CITY OF ALBUQUERQUE

March 22, 2019

**RE: Maverik – Unser/Los Volcanes
551 Silver Creek Rd. NW
Grading and Drainage Plan & Drainage Report
Engineer's Stamp Date: 03/19/19
Hydrology File: K10D023D**

RONALD R. BOHANNAN P.E. #7868	<b>MAVERIK STORE #NM-0115</b> <b>UNSER AND LOS VOLCANES</b>		DRAWN BY pm
	<b>GRADING DETAILS</b>		DATE 5-2-19
	 <b>TERRA WEST, LLC</b> 5571 MIDWAY PARK PL NE ALBUQUERQUE, NEW MEXICO 87109 (505) 858-5100 www.tierrowestllc.com		SHEET # <b>GR-2</b>
			JOB # 2018042

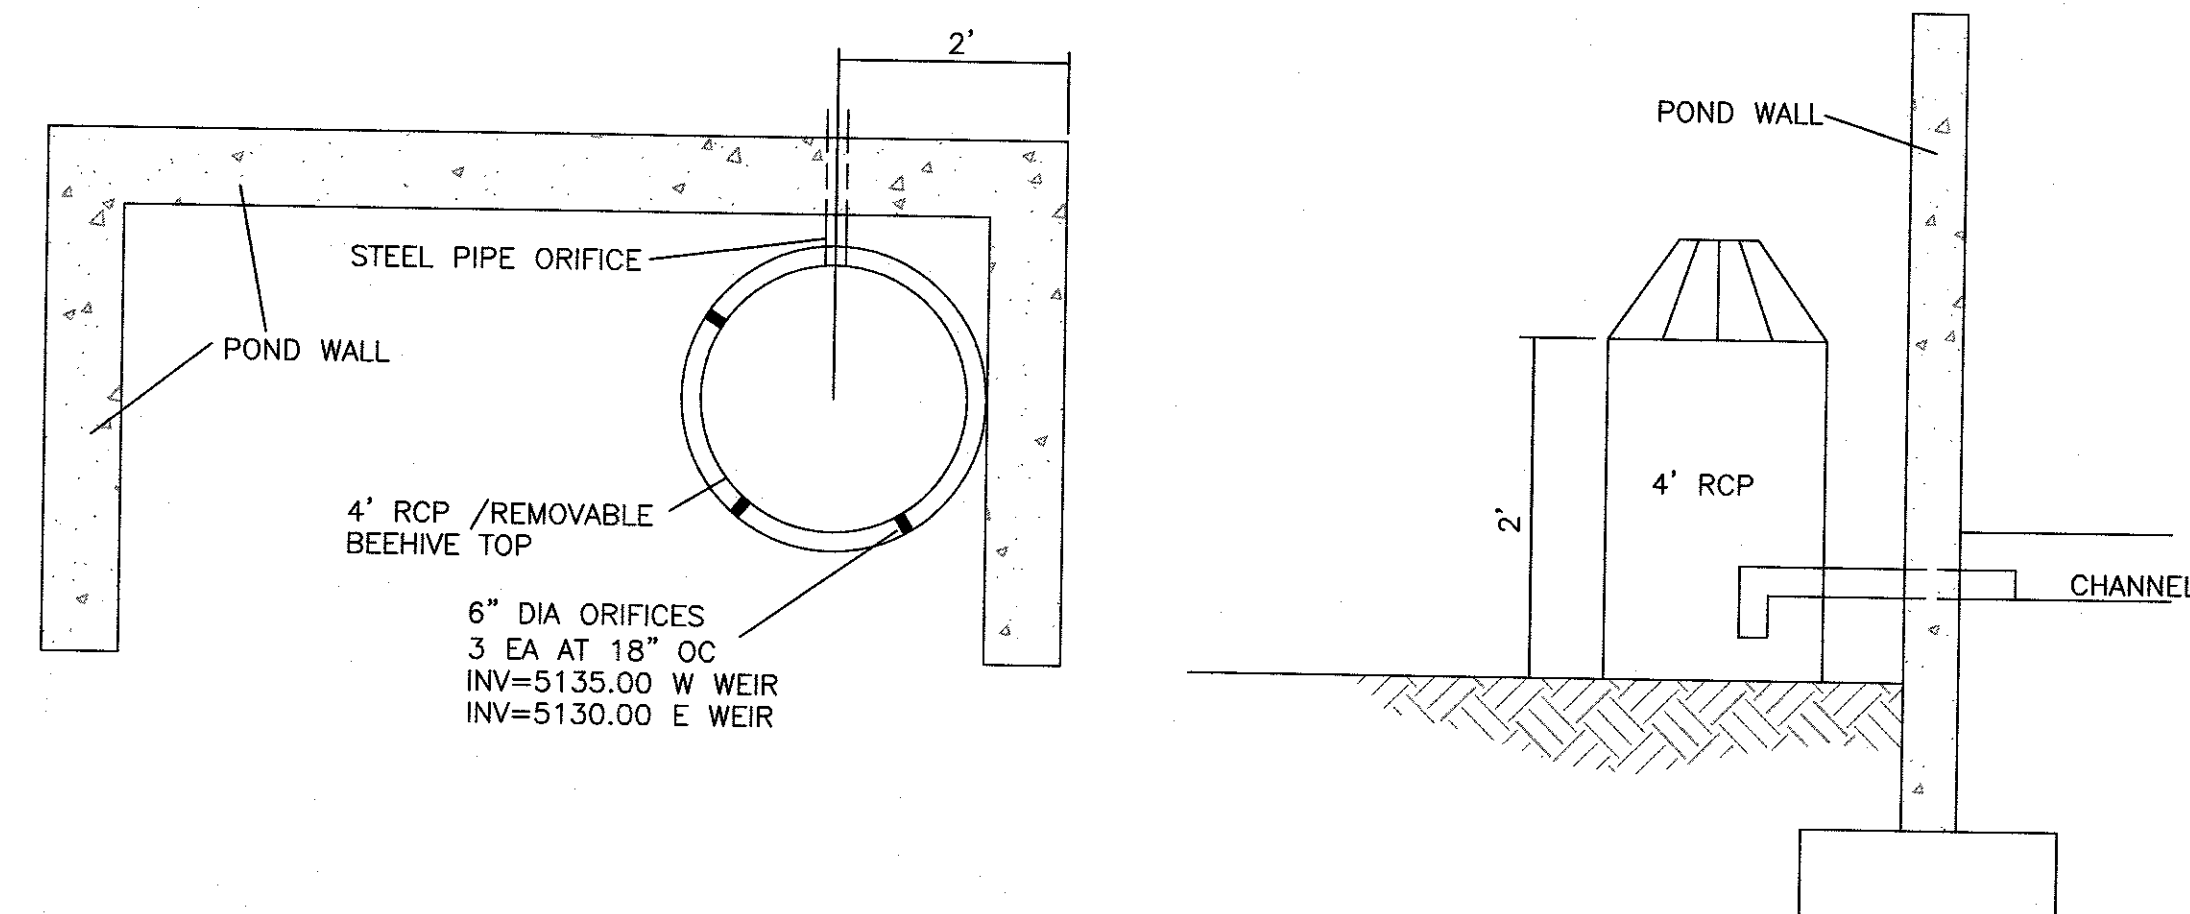
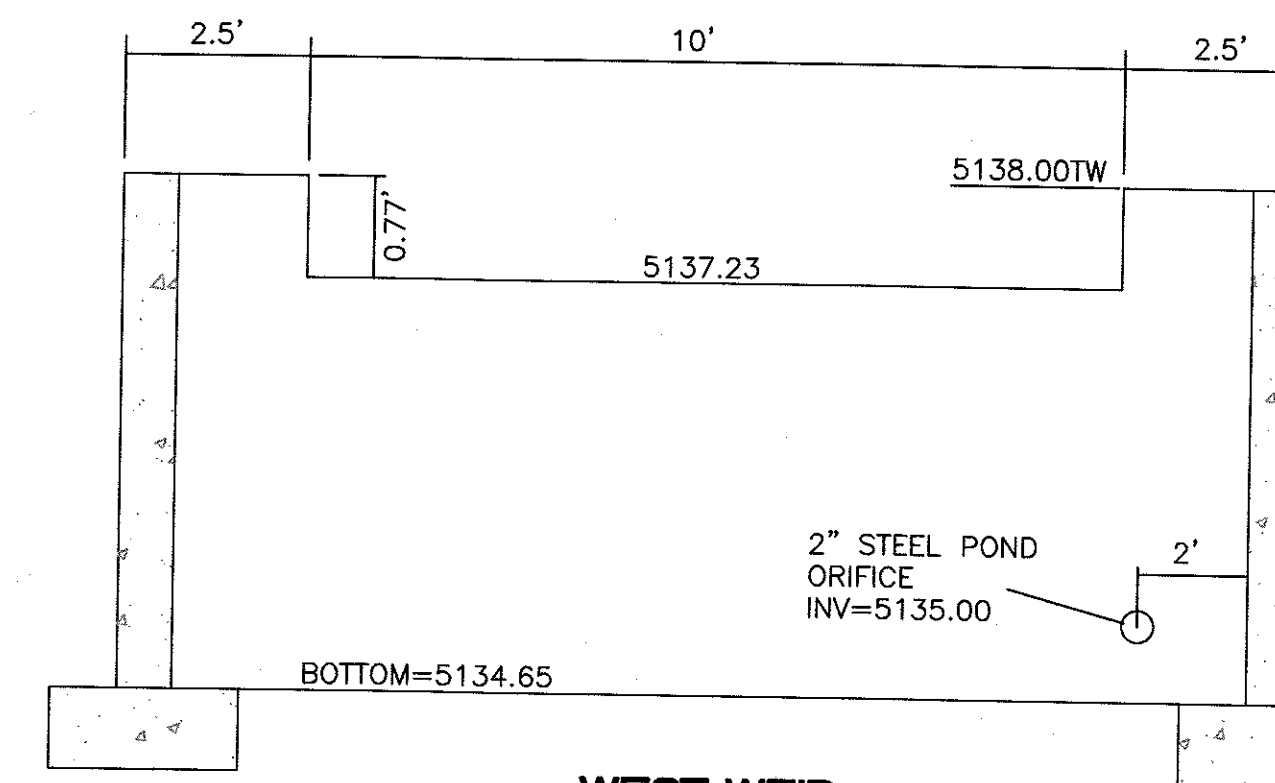
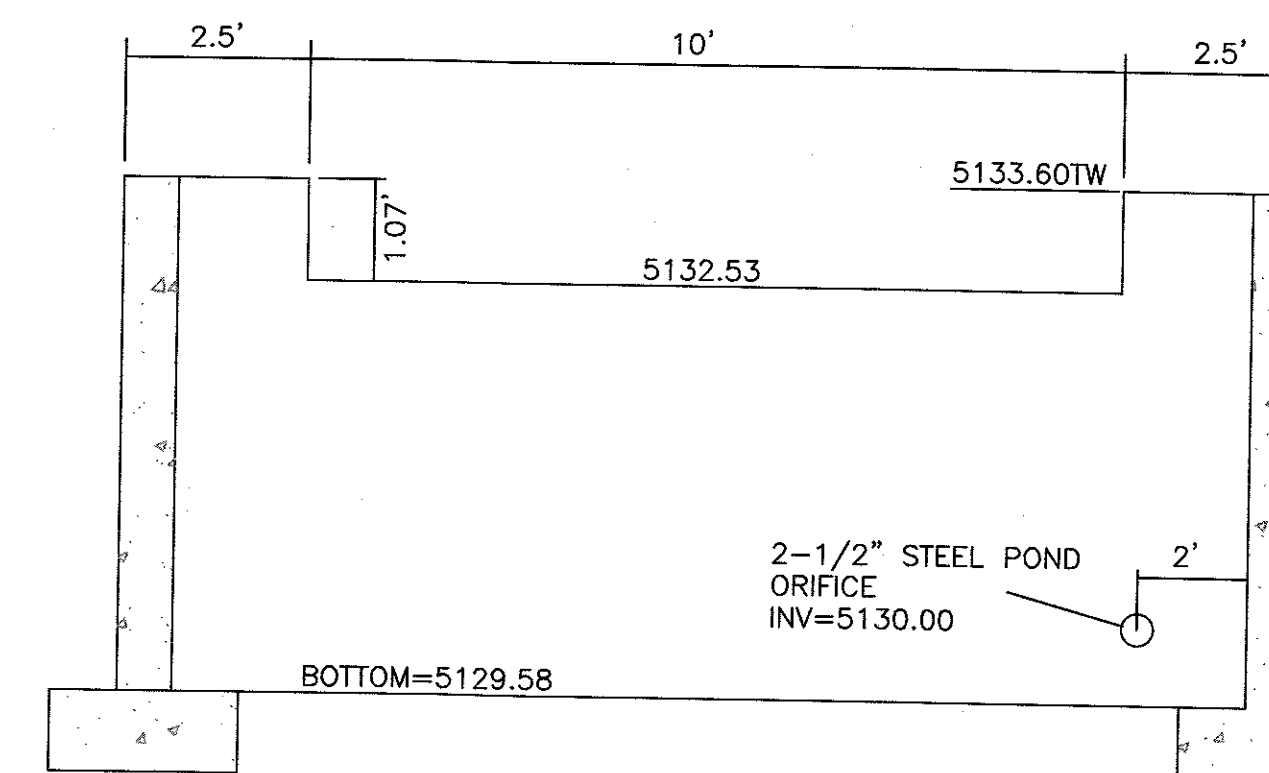
11. Grading Plan. For both the West Pond and East Pond, please provide the emergency spillway detail that matches the weir equations in the Drainage Report.

12. Grading Plan. For both the West Pond and East Pond, please provide a detail showing the elevation and pipe size of the pond's orifice.
13. Grading Plan. In Section A-A, please show the top of wall elevation, call out the railing, WSE, label each pond, and note the orifice & spillway for each pond.
